PRE-REGISTRATION CHECK SHEET – TO BE COMPLETED BY DUTY OFFICER AS APPROPRIATE

Application Ref: 24/00191/DPP Pre-application Ref: _____ Online App

<p>UPRN: 000120029346 (If NO UPRN – Admin to contact Technician)</p> <p>Site Address: <i>(Leave blank if no UPRN)</i> 160 MAIN STREET PATHHEAD EH37 5SG</p>	<p>Description of Proposal: Erection of two storey rear extension; installation of rooflights;; and replace roof material.</p>
---	---

PROPOSED | SECTION A-A 1:50

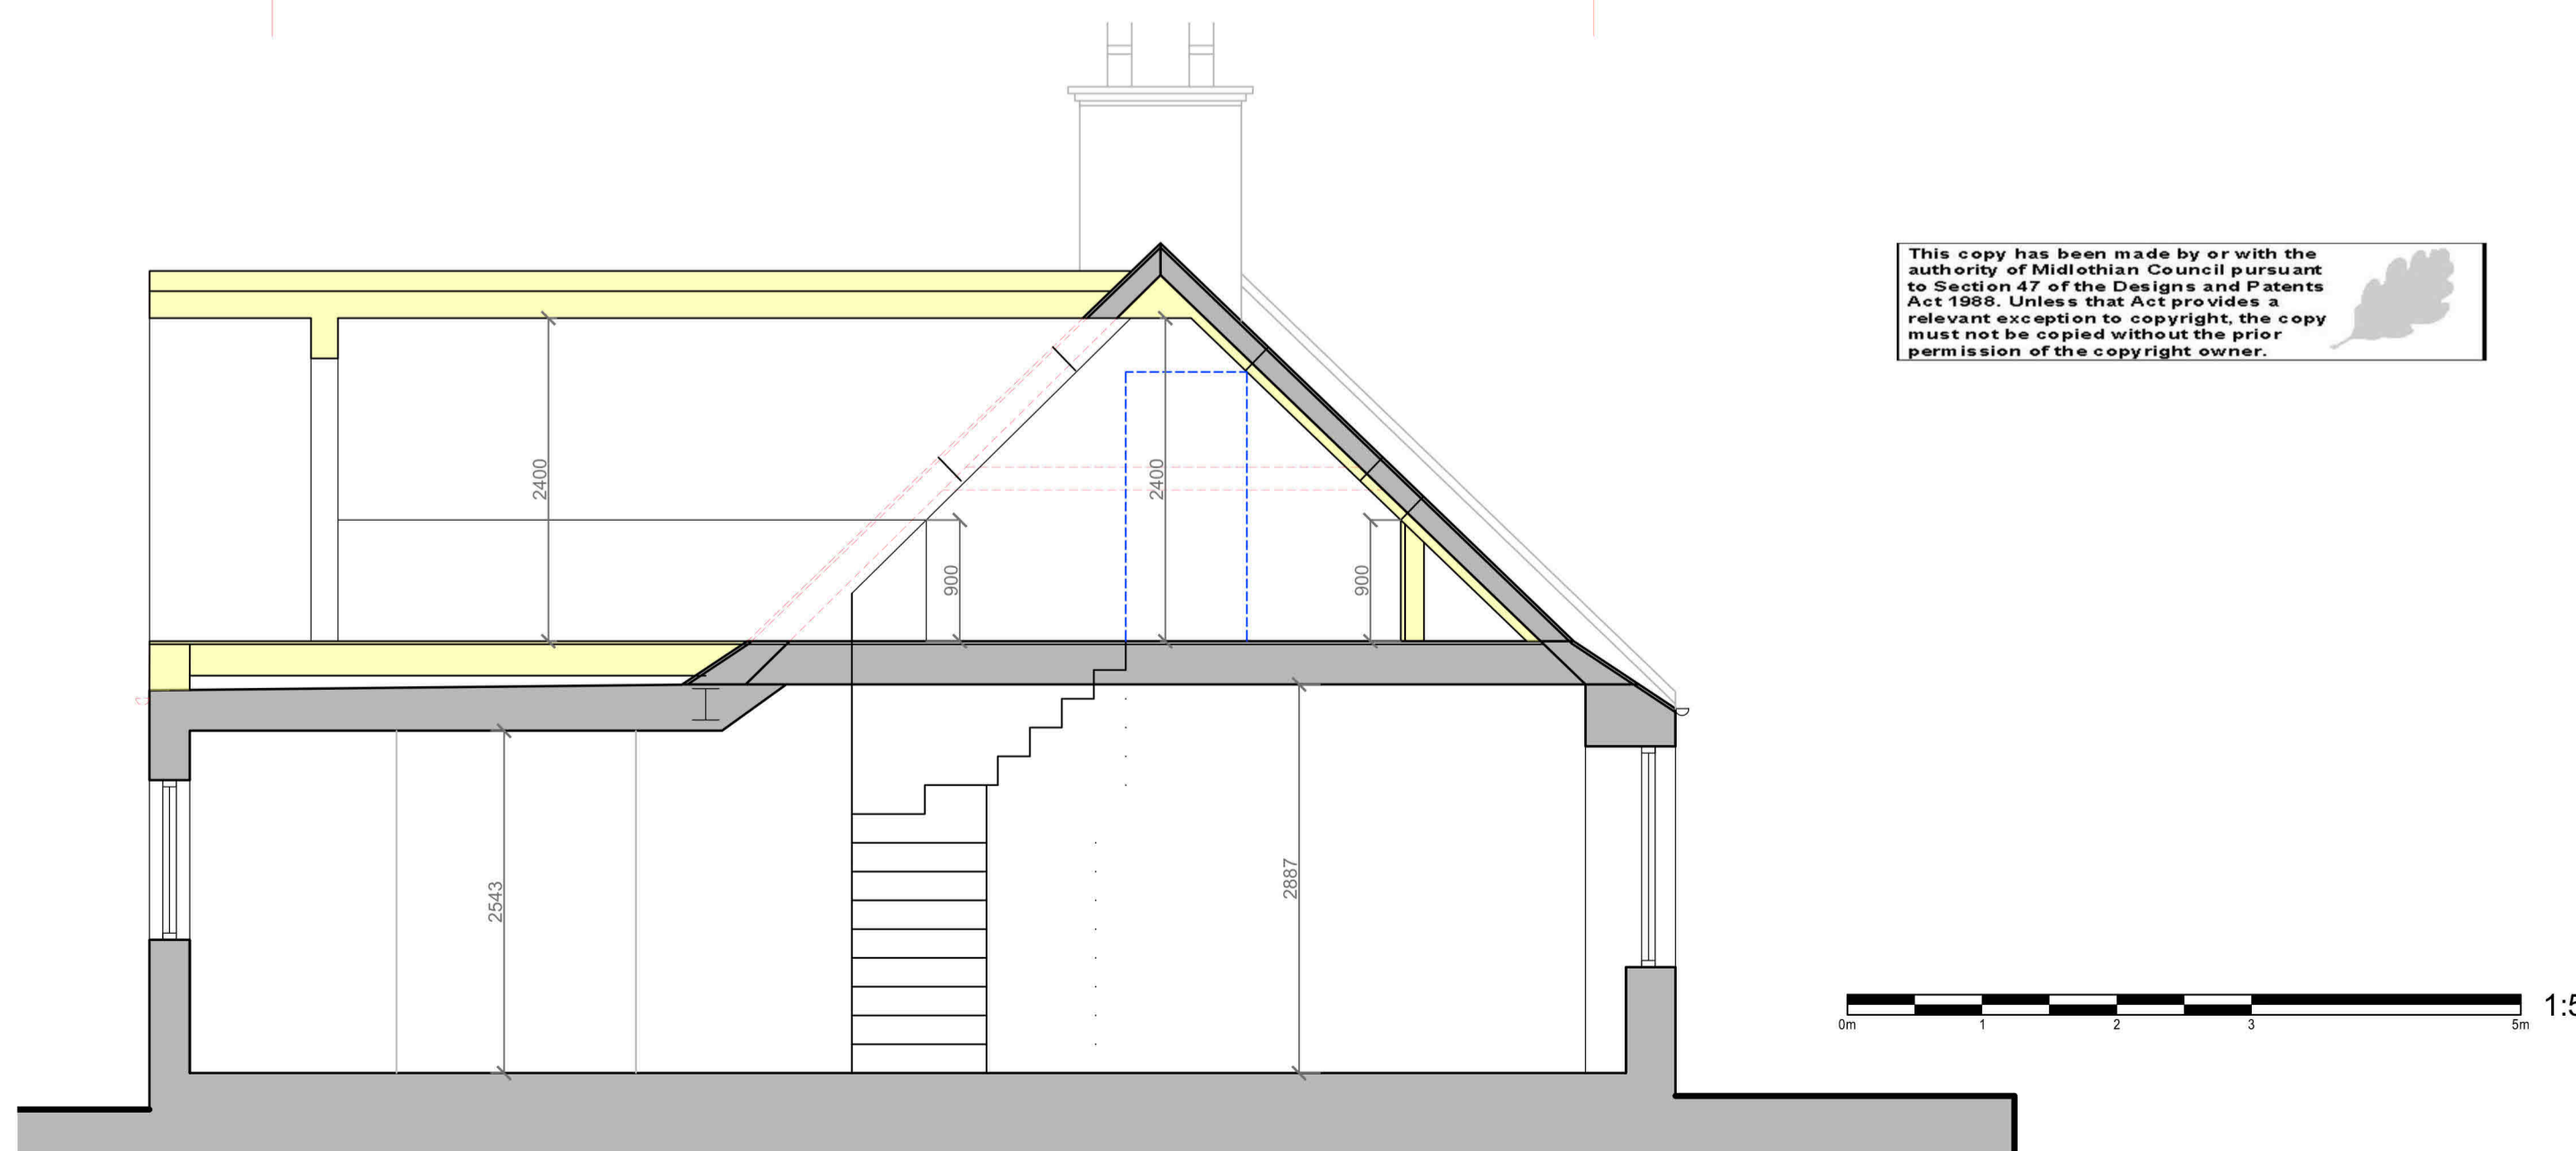
The rooflight being installed on the rear extension, as shown on the roof plan, is not shown on the proposed side elevation.
